Rezoning Transportation Analysis

Petition Number: 2020-066

General Location Identifier: Tax ID 21313828

Date	Description
5/18/20	First Review (MM)

RZ-1.0

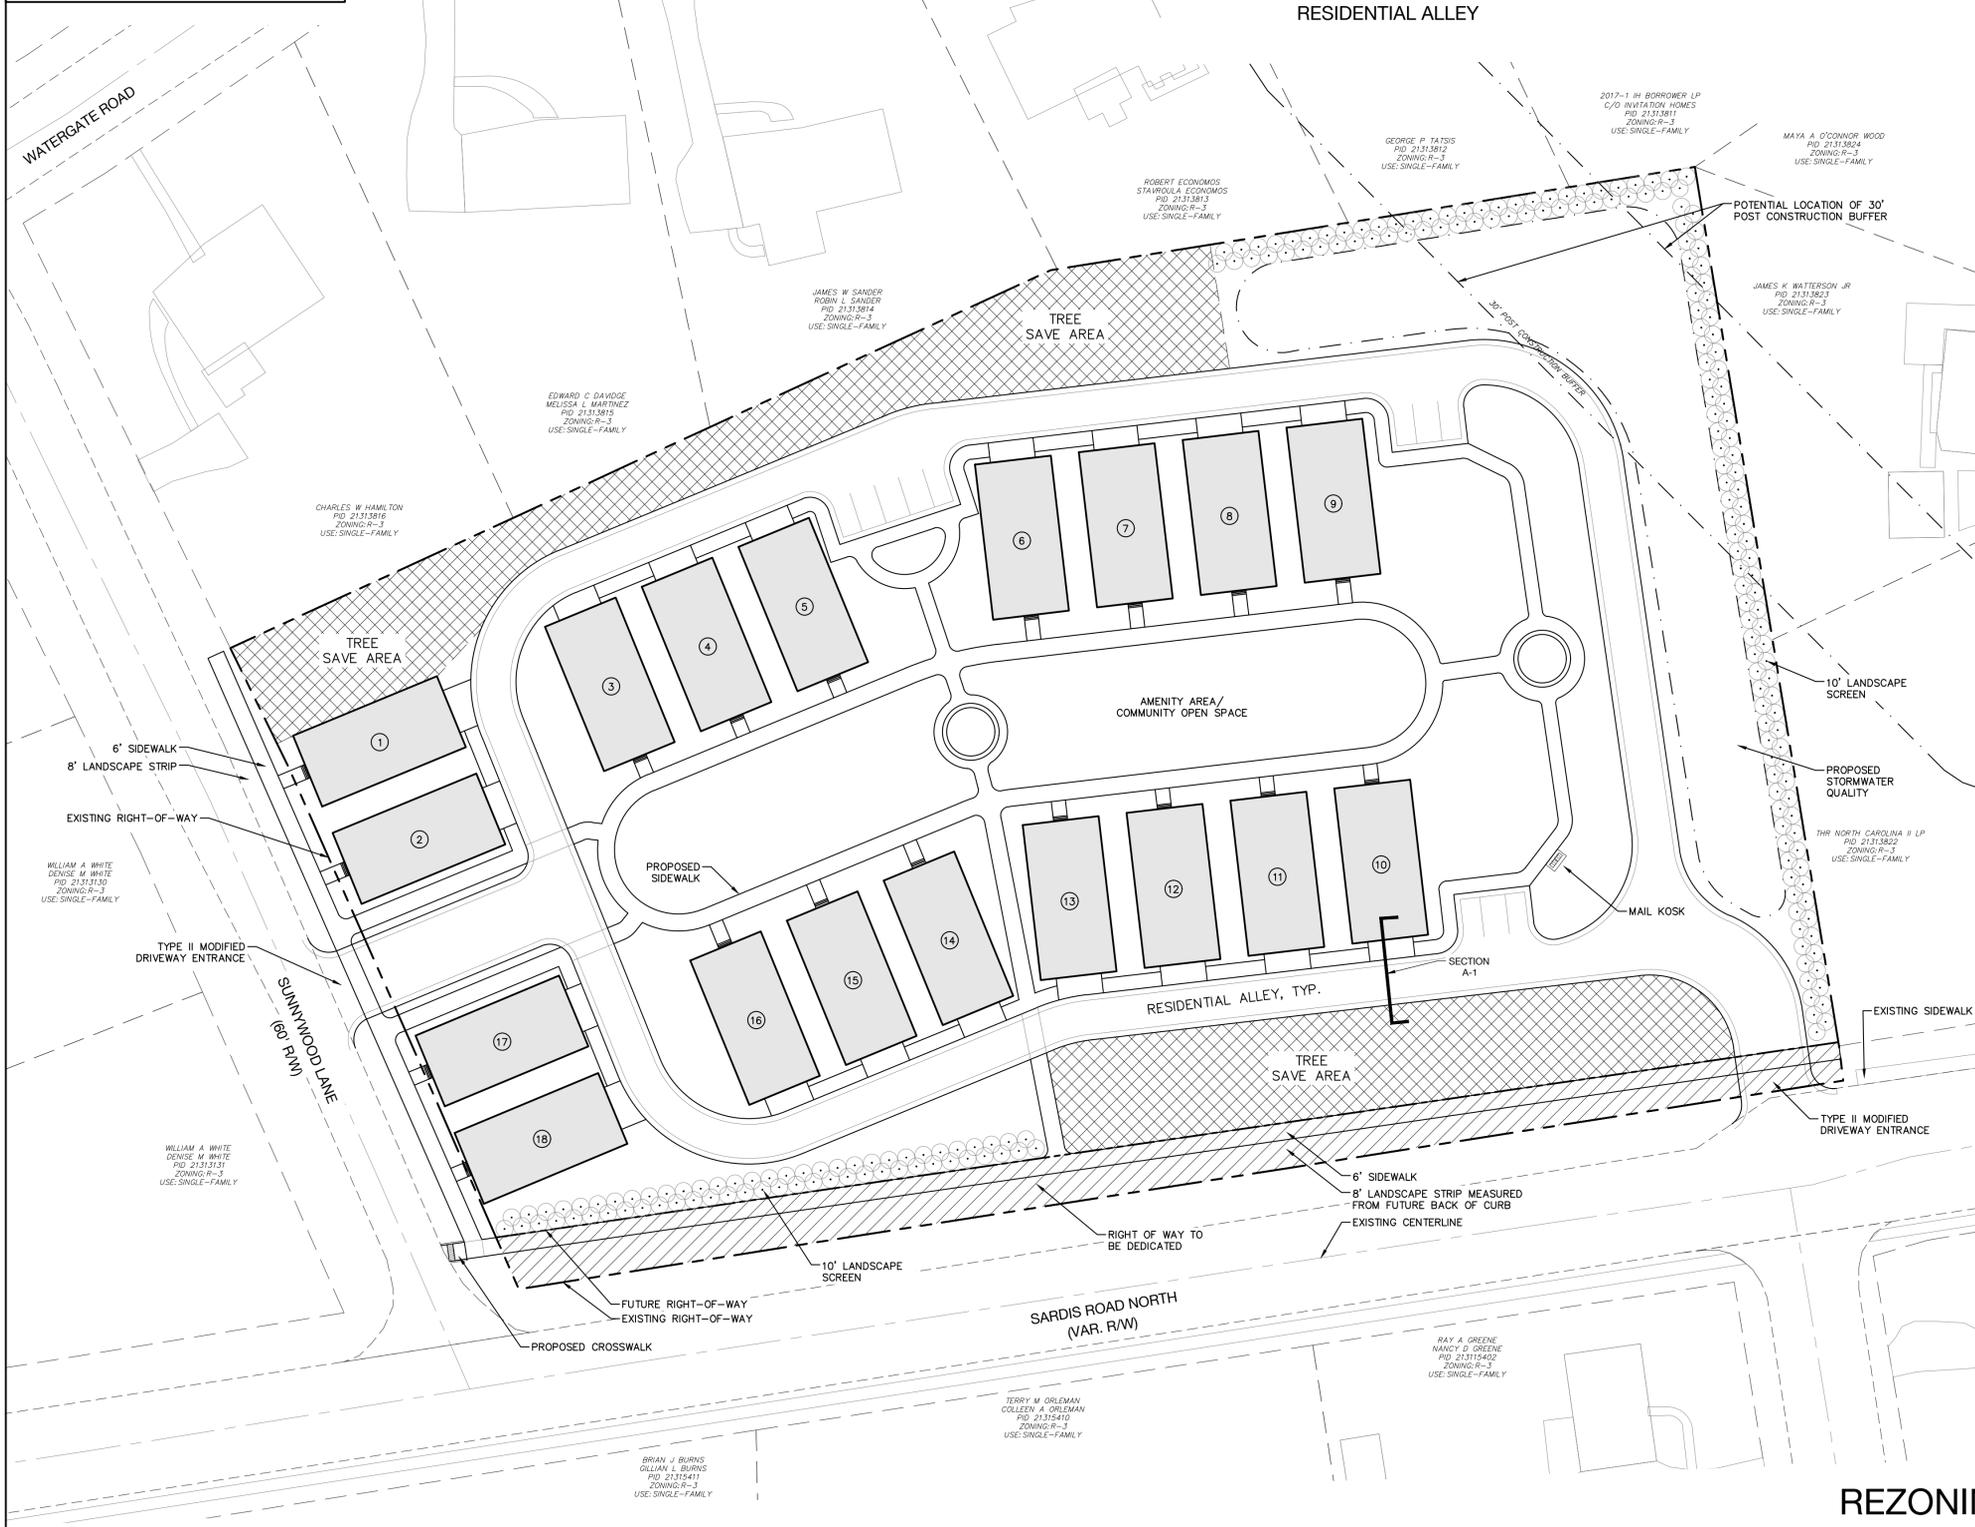
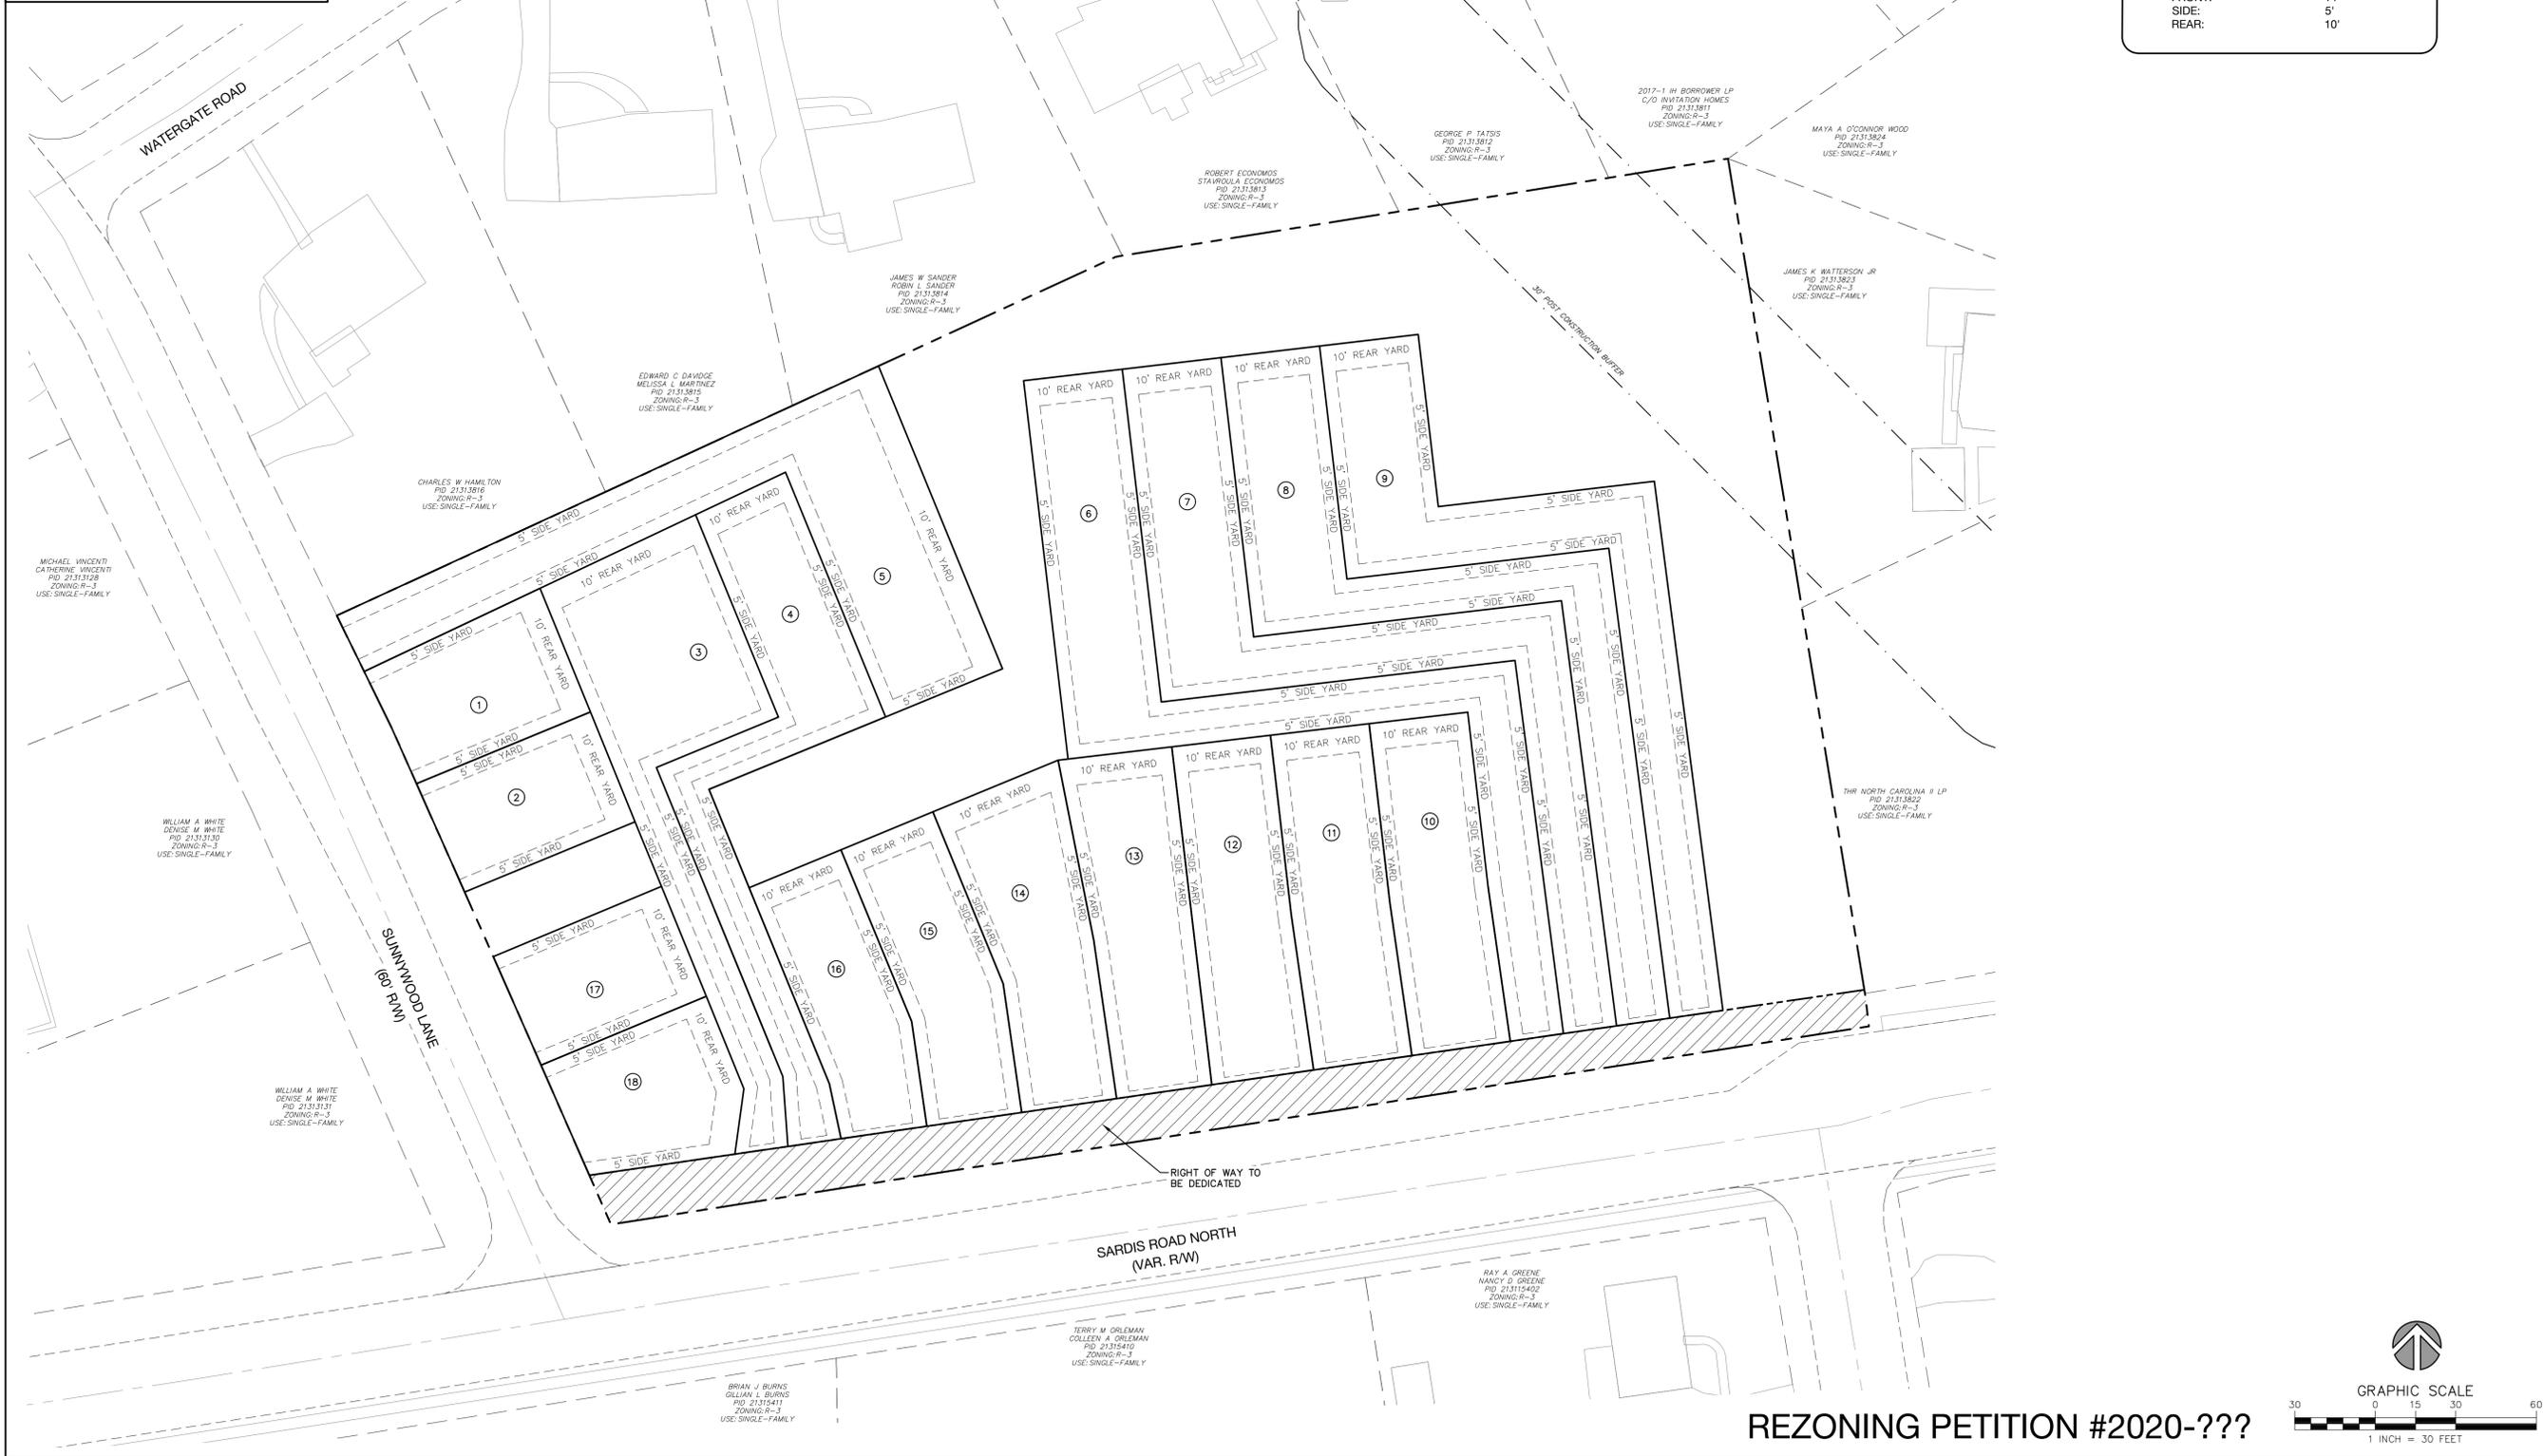
1. **Curbline** The proposed zoning district has a setback measured from back of the existing or proposed future curbline.
 - a. **Sardis Rd. North:** The future location of curb and gutter needs to be 26.5' centerline to face of curb.
 - b. **Sunnywood Ln.:** The future location of curb and gutter needs to match a residential medium cross-section.

The site plan should show the curb and gutter labeled and dimensioned from the centerline for each road.

2. **Traffic Study** A Traffic Impact Study is not necessary for the complete review of this petition. If during the permitting process the site generates more than 2500 daily trips, then a traffic study will be required.
3. The petitioner should revise the site plan and conditional note(s) to commit to constructing a left-turn lane on Sardis Rd. North to the proposed access point.
4. The petitioner should revise the site plan and conditional note(s) to commit to constructing a pedestrian refuge island in the existing gore of Sardis Rd. North just east of Sunnywood Ln. and an accessible ramp on the south side of Sardis Rd. North.

5. The petitioner should revise the site plan and conditional note(s) to funding the cost of a pedestrian hybrid beacon (PHB) at the pedestrian crossing described in comment 3. Traffic volumes and speeds on this part of Sardis Rd. North are high enough that a pedestrian refuge island alone is insufficient.
6. **Resolved** ~~Sample format for comment that is resolved~~
